AQUIND INTERCONNECTOR

Applicant's Response to Deadline 7 and 7a
Submissions

Edited down to contain Winchester City Council
responses only for submission at Deadline 8
(1 March 2021).

Document Ref: 7.9.39

**Plate 2 – Typical Compound Area for Joint Bay**

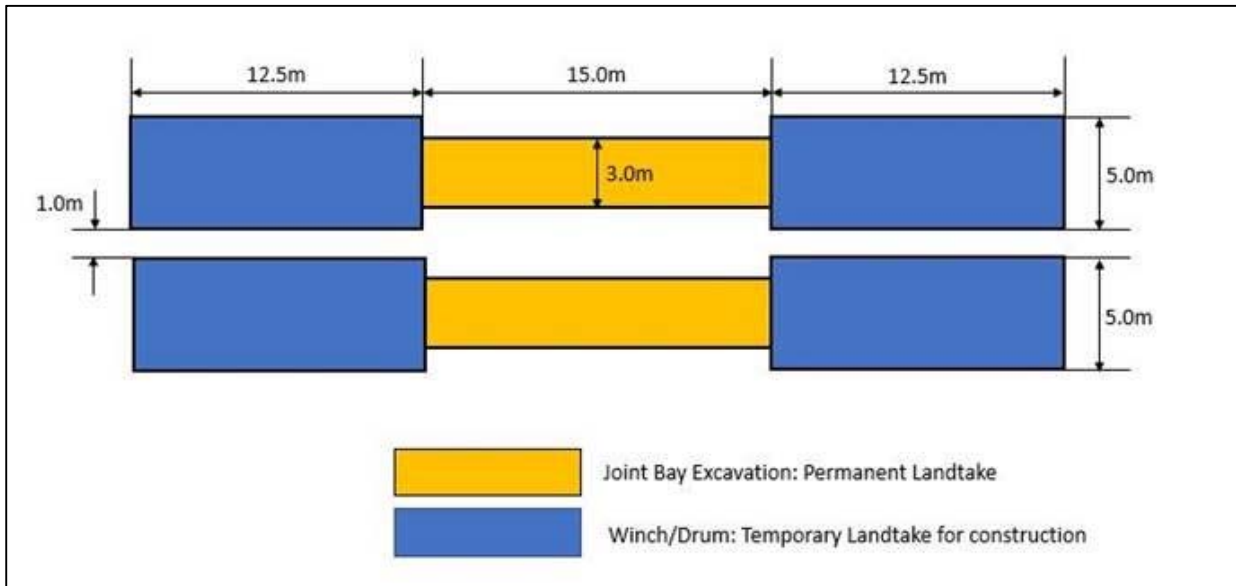
<p>JB6 is shown as straddling the car parking area at the western end of Southview Road and a section of the highway. However, the text alongside the diagram indicates that the JB will be located within the car park. A straddling position would mean the total loss of the boundary hedgerow. Clarification is requested on the precise location of the JB and the temporary land take to facilitate its construction. The Council recognises the constraints in identifying an alternative location within the order limits. However, it considers that the applicant should clear the highway completely.</p>	<p>The Joint Bay Technical Note (REP7-073) is an indicative feasibility study which shows the indicative locations of joint bays along the cable route. The standard joint bay area, delivery area and work compound area are provided in Section 1.3 of Joint Bay Technical Note. It is noted that a delivery area is shown straddling the highway, but that this delivery area would be used for a very short duration (likely no more than a few hours) for the delivery of a cable drum only.</p>	Noted

<p>In the event that the area shown is used for a Joint Bay then the detailed design of the Joint Bay area will be, as far as is reasonably practicable, located off carriageway unless such positioning is unavoidable taking into account environmental and other constraints.</p>	
	<p>It is unclear at the present time, exactly how much of the boundary between the car park and the road will be temporarily lost to the project.</p>	<p>The Joint Bay Technical Note (REP7-073) is an indicative feasibility study which shows the indicative locations of joint bays along the cable route.</p>	<p>Noted</p>

Figure 1 – 2019 NVC survey results, field numbering and HDD5 reception compound.

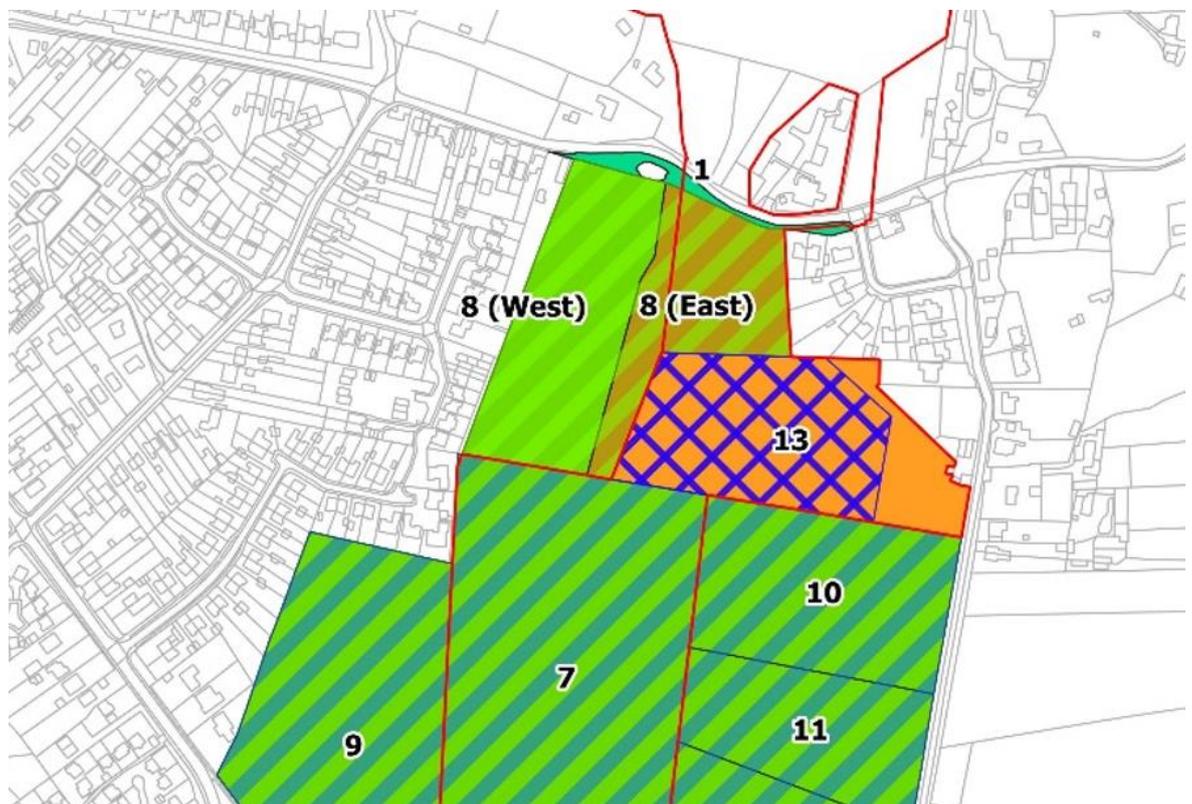
The technical reasons why the drilling section cannot be extended northward to emerge on the agricultural land north of Anmore Road have already been outlined and accepted. This leads to the conclusion that the compound has to be located south of the Anmore Road. Accordingly, the Council feels that the focus should be on minimising any impacts from its temporary presence.

The applicants intentions are to remove a layer of soil and then reinstate this using any surplus seed from the seed harvest undertaken as part of the restoration of the land at the southern end. Leaving the soil in situ and using protective mats and teram should be considered together with seeding.

When constructing the open trenches careful removal of the seed bearing layer of soil with the use a micro digger or light pressure equipment with access limited to the smallest area necessary should be considered. The Council is ready to discuss with the applicant the

The Applicant welcomes agreement with WCC regarding the need for the HDD5 reception compound (the “northern recovery drill compound”) location.

The Applicant will review its mitigation proposals in light of the Hampshire Biodiversity Information Centre report (“Kings Pond Meadow Habitat Survey May 2020”) to ensure they fully offset impacts and the potential for residual effects, and welcomes the offer from WCC to discuss the methodology adopted to undertake the work and reinstate the ground.

The Applicant has continued discussions with both Winchester City Council and Natural England regarding this matter and in particular the scope of mitigations proposed for Fields 8 (east) within Kings Pond Meadow SINC and Field 13. These discussions are at an advanced stage and broadly agreed with WCC.
